PROPOSED LIDL FOODSTORE

**Former Hayes Pool and Fitness Centre,
Central Avenue, Hayes Town**

**Addendum Transport Assessment:
Appendices A - E
On behalf of Lidl UK**

Response to Highway Officer Comments

Site Access Arrangement Drawing

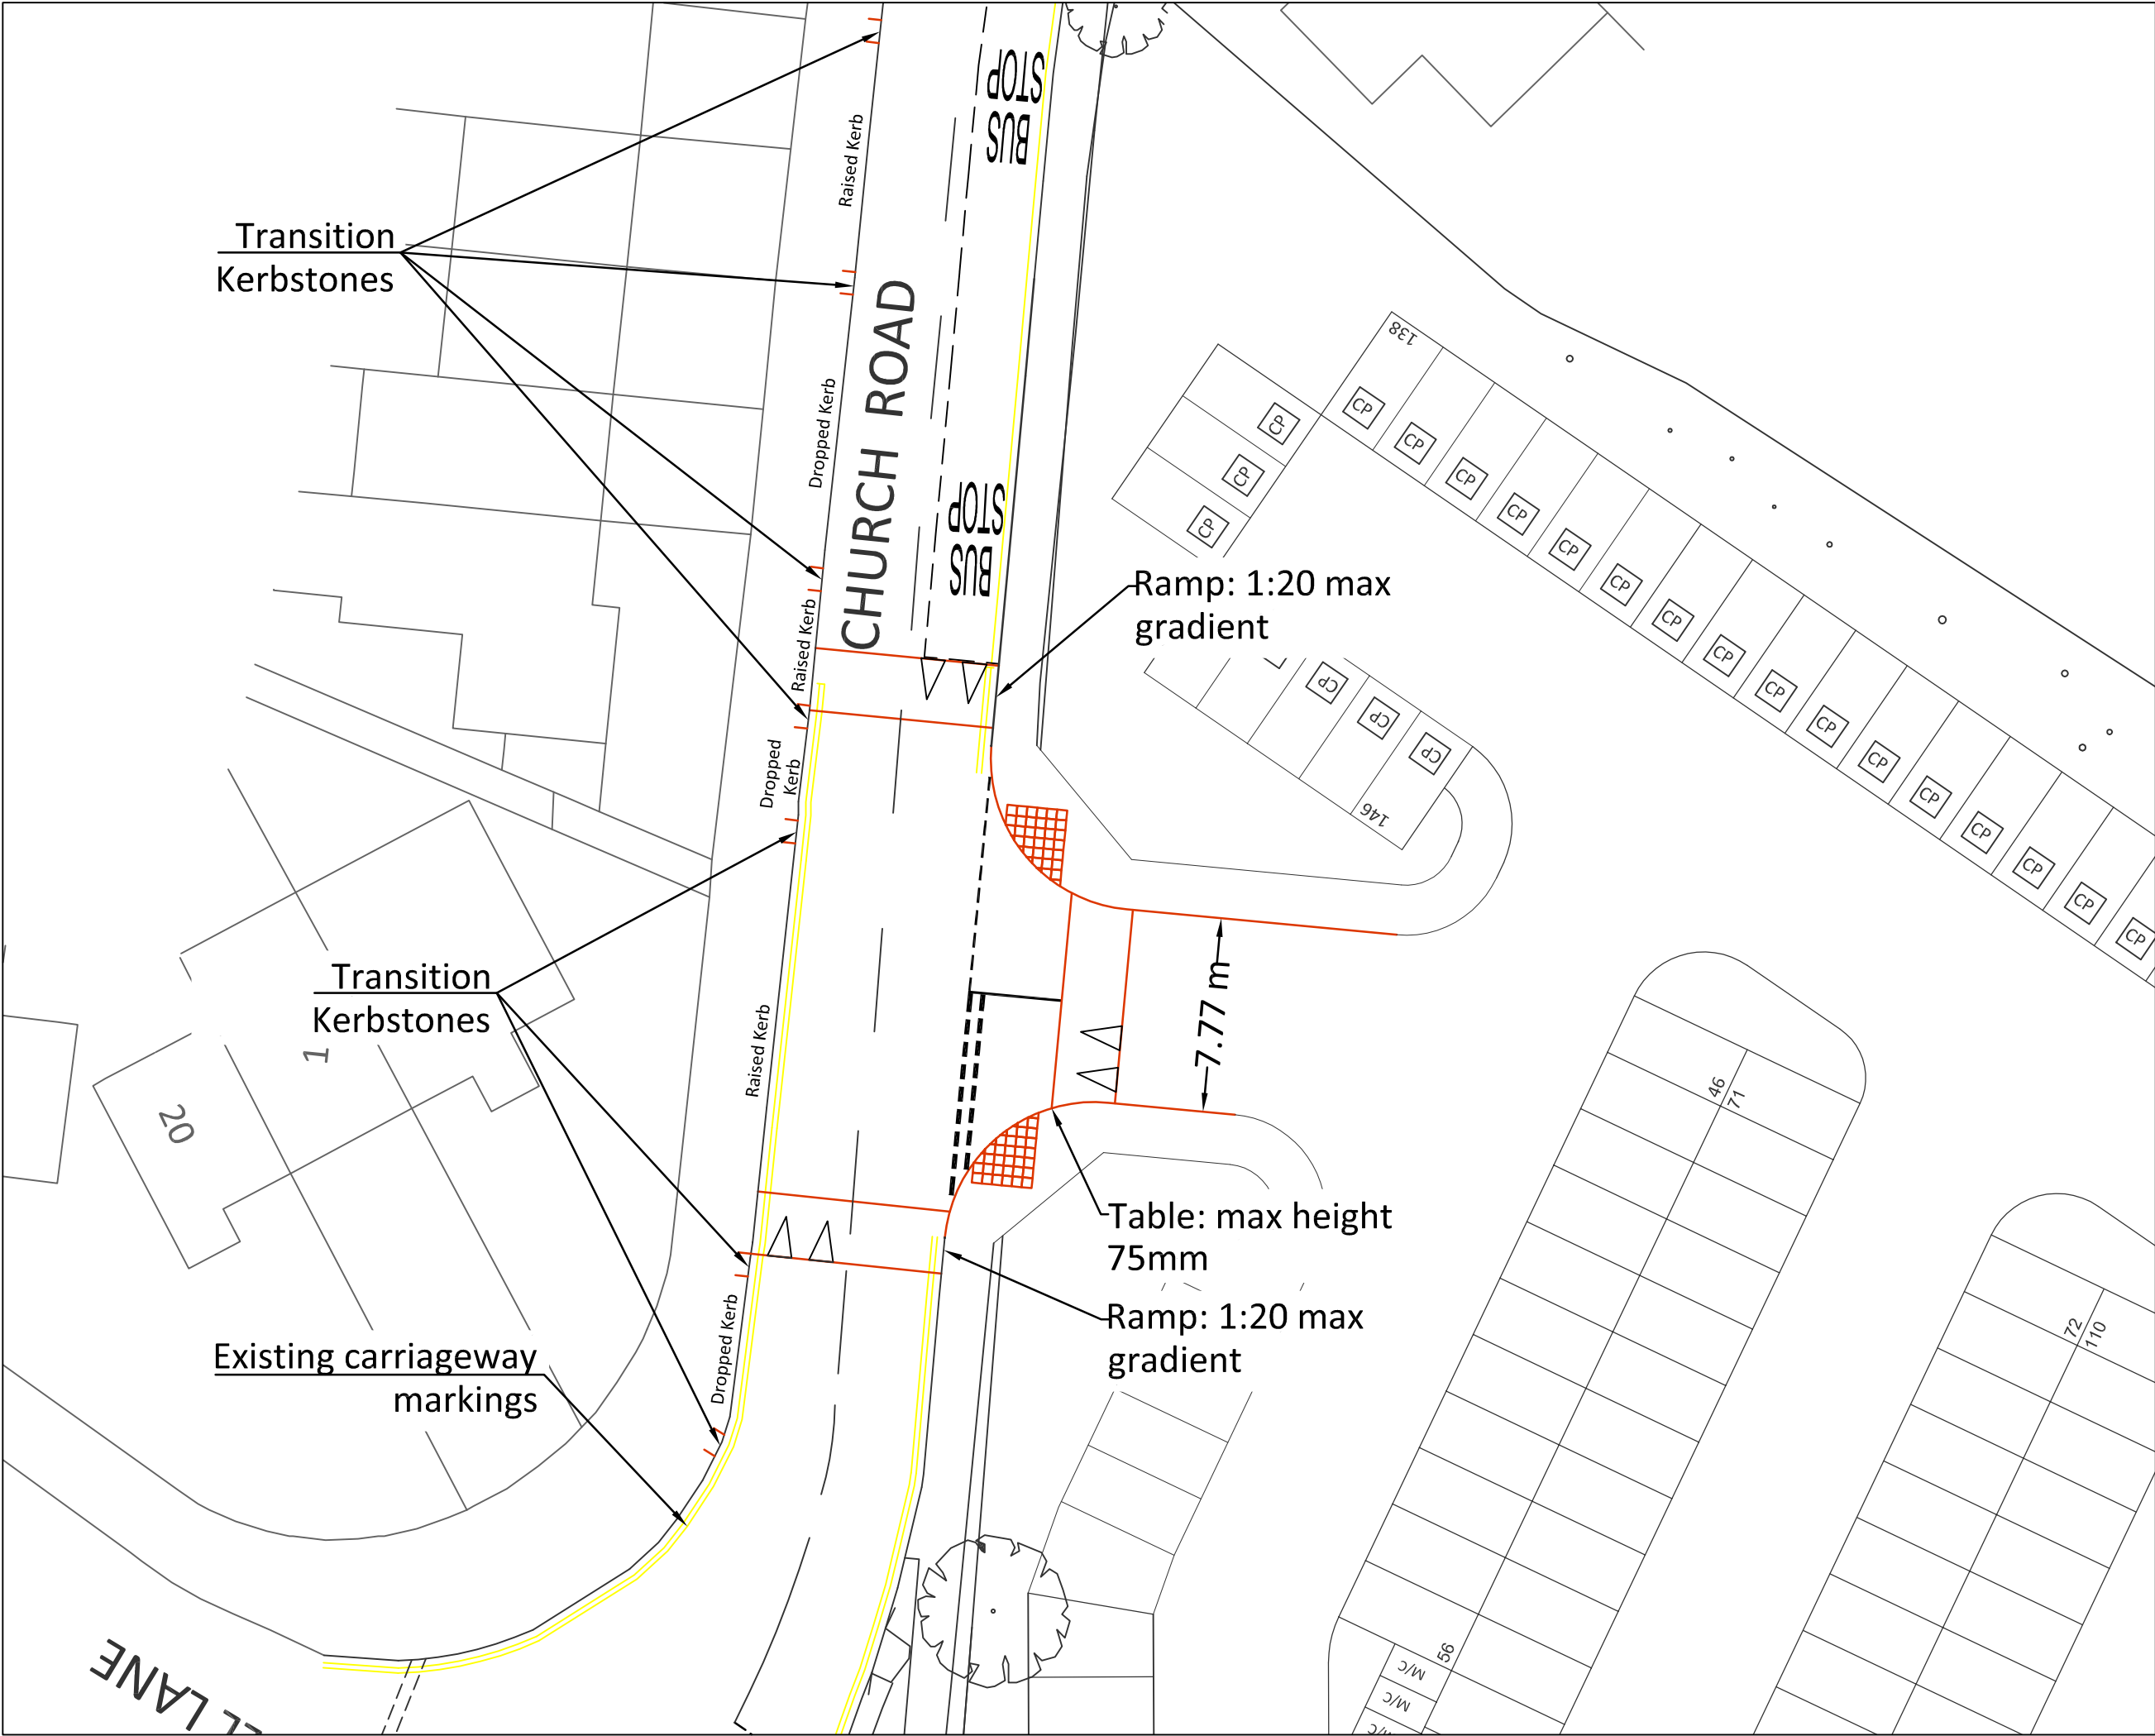
“Location of the proposed access in close proximity to the bus stop and vehicle crossover opposite is unsatisfactory due to concern relating to sightlines and conflicting traffic movements.”

- 4 To address the issues with visibility, two drawings have been created to provide the visibility splays associated with the proposed access arrangement. Drawing 15/0302/SK06, which is included at **Appendix A**, demonstrates the achievable visibility splays along Church Road, showing 2.4 by 43 metres to the north and 2.4 by 34 metres to the south, accounting for the proximity of the roundabout junction.

- 5 Drawing 15/0302/SK07, which is included at **Appendix B**, has been created to demonstrate the practical visibility achievable when a bus is present at the bus stop. London Buses require drivers to pull up in line with the bus stop flag (or shelter, but since no shelter is provided in this location it is not applicable). In this drawing the visibility splay is measured 0.5 metres into the carriageway, measured from the edge of the stationary bus. This allows all vehicles, including cyclists, to be seen as they would not realistically be positioned closer whilst overtaking the vehicle, providing the Church Road carriageway is clear from obstructions.

- 6 The practical visibility indicates that 23 metres would be achievable from the Lidl site access junction to the north. This is equivalent to an oncoming vehicle speed of 19 miles per hour. Given the proximity to the Botwell Lane roundabout, it is not considered likely that cars would overtake the bus at the posted speed limit due to potential oncoming vehicles entering the road from the roundabout. On this basis, the practical visibility achievable reflects the likely vehicle speeds in the event that a vehicle is able to overtake a stationary bus.
